20 March 2017

Cameron Sargeant, Team Leader, Key Sites Assessments
NSW Department of Planning and Environment
Sydney NSW 2000

State Significant Development Application SSD 7246: Foreshore and Public Domain Works at Campbell's Cove, The Rocks

02 INTERPRETIVE SHORELINE PAVING DETAIL
SCALE 1:20

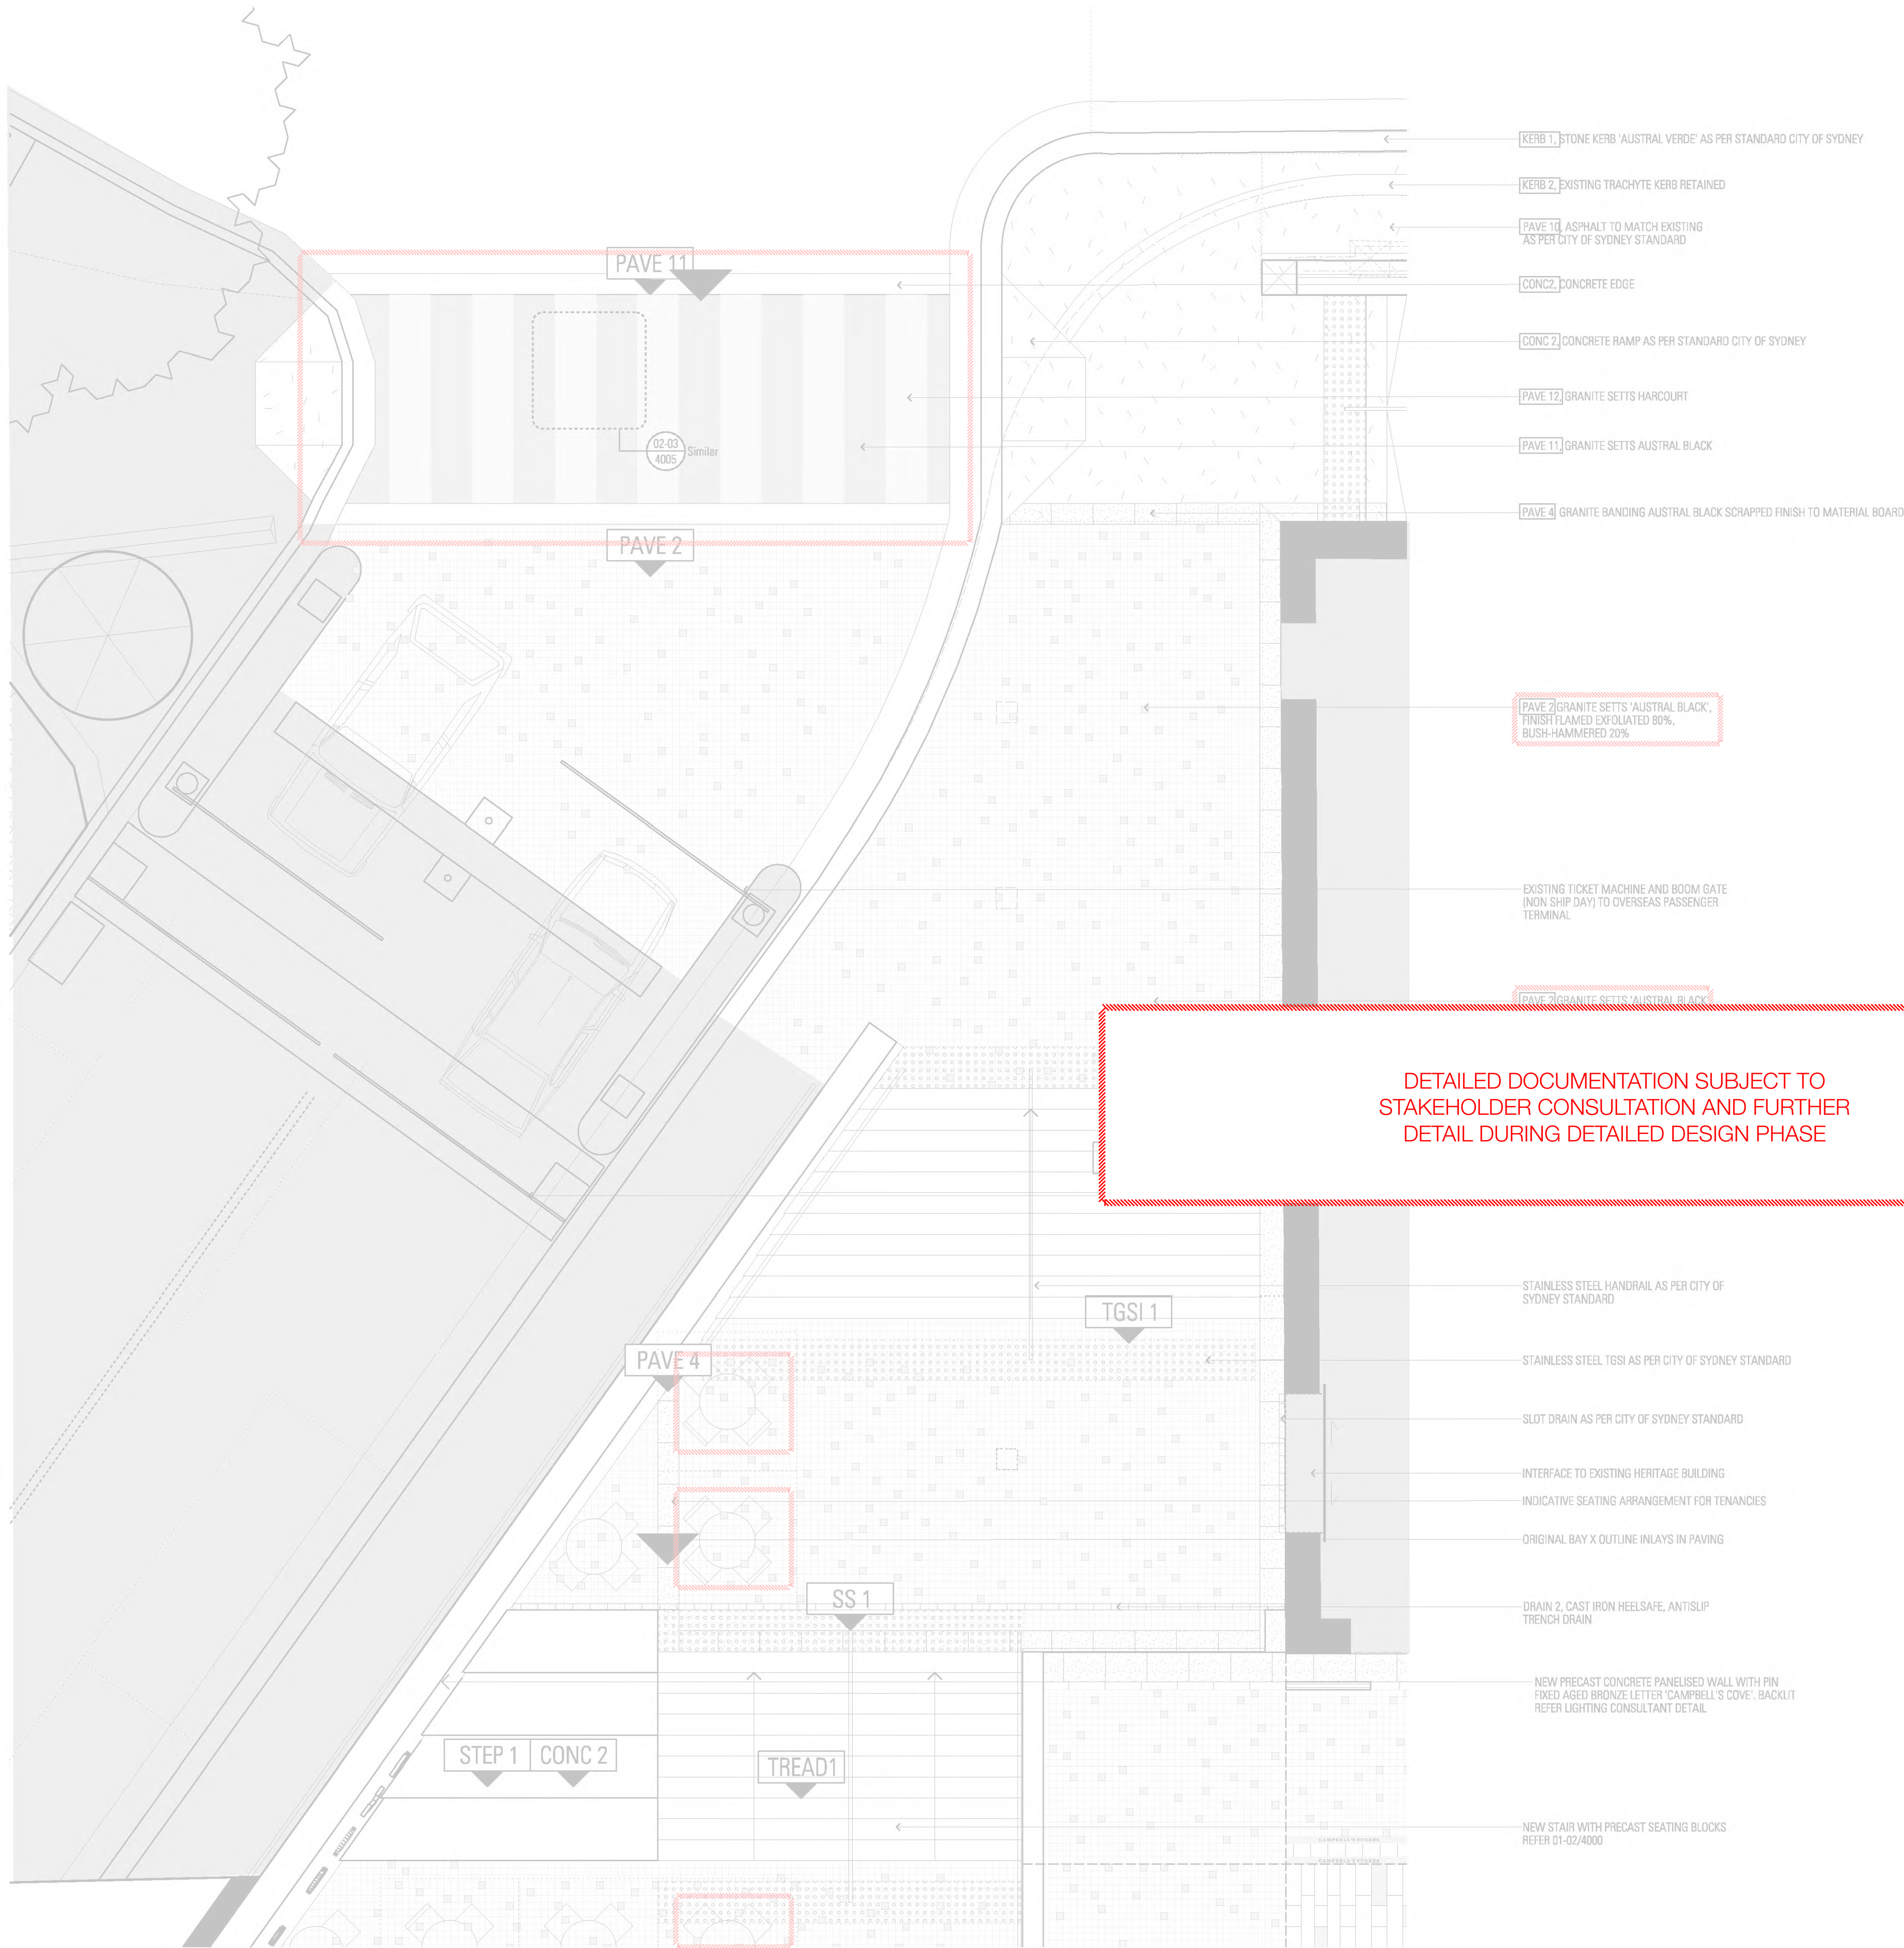
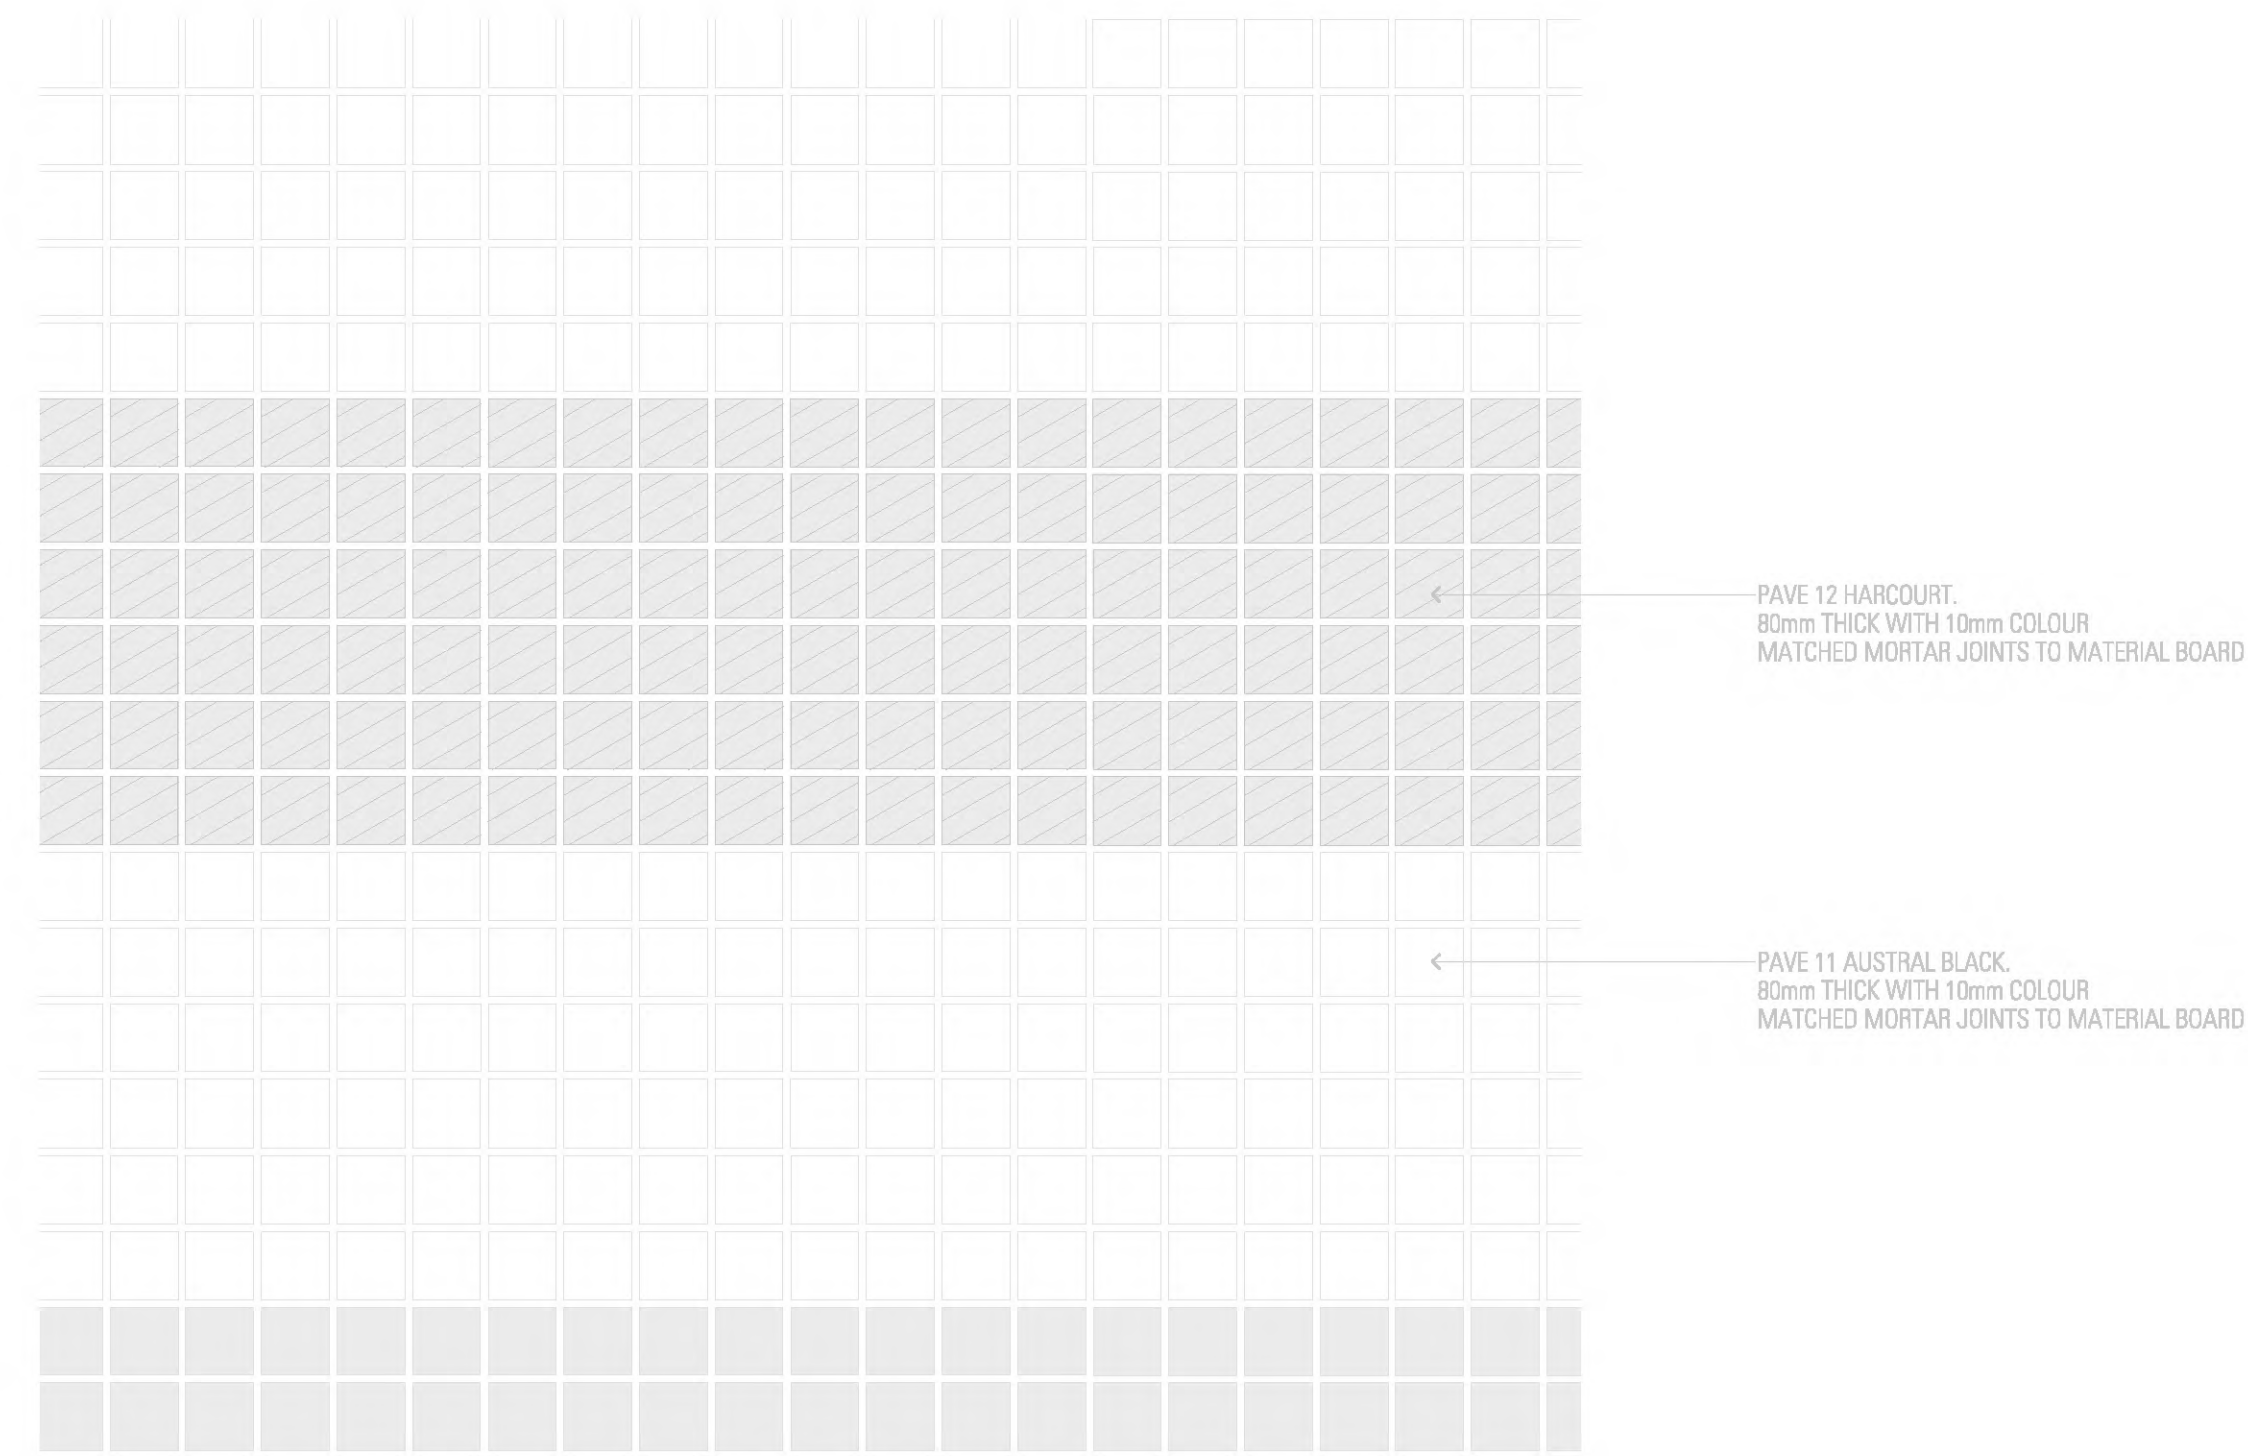
While the proposed shoreline interpretation is legible when drawn in plan, the City is concerned that it will not be very legible as a built element given that only a small portion of it exists in the open public domain area.

It is recommended that the interpretive shoreline paving detail should be deleted and replaced with bronze inlays, as currently exists in Circular Quay East.

02 PEDESTRIAN CROSSING DETAIL
SCALE 1:50

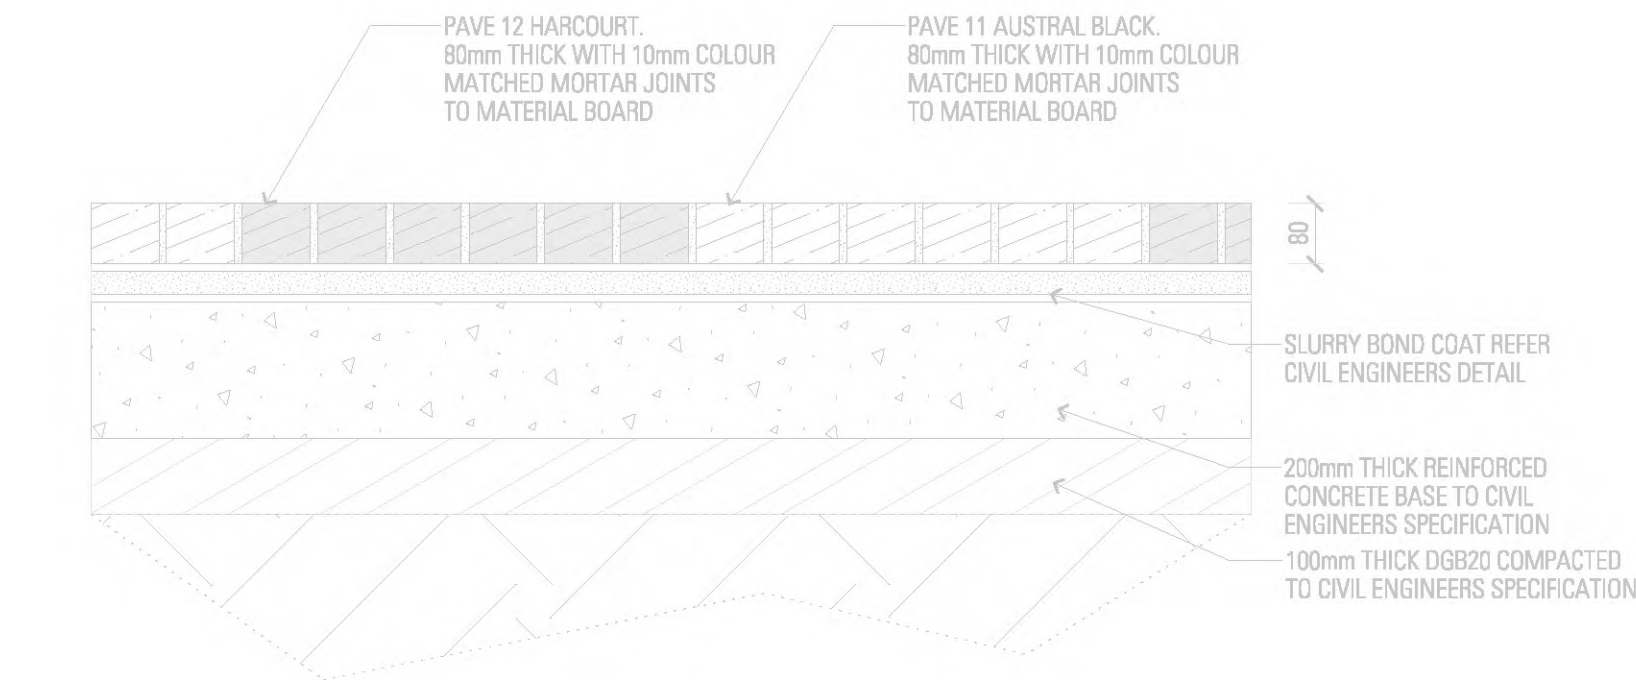
The City notes that a new pedestrian crossing is proposed at the entry to the Overseas Passenger Terminal Bridge from Hickson Road. The City does not support a full crossing at this location as it may contribute to an over proliferation of crossings in the locality, reducing their importance in the mind of the driver, and thereby reducing their efficacy at other, more crucial locations.

The City would prefer vehicular access to be redesigned to give priority to pedestrians and cyclists. This can be achieved by continuing the type of footpath material and grade (i.e. continuous footpath pavement) as recommended in Section 3.11.11 (6) of the Sydney Development Control Plan 2012. The pedestrian has the right of way whether a crossing is there or not, but the different texture from the roadway will reinforce the need for vehicles to 'give way'. It is recommended that the applicant refer to the Sydney Street Design Code for further details.

If the full pedestrian crossing is to be pursued, advice from RMS should be sought to confirm its support.
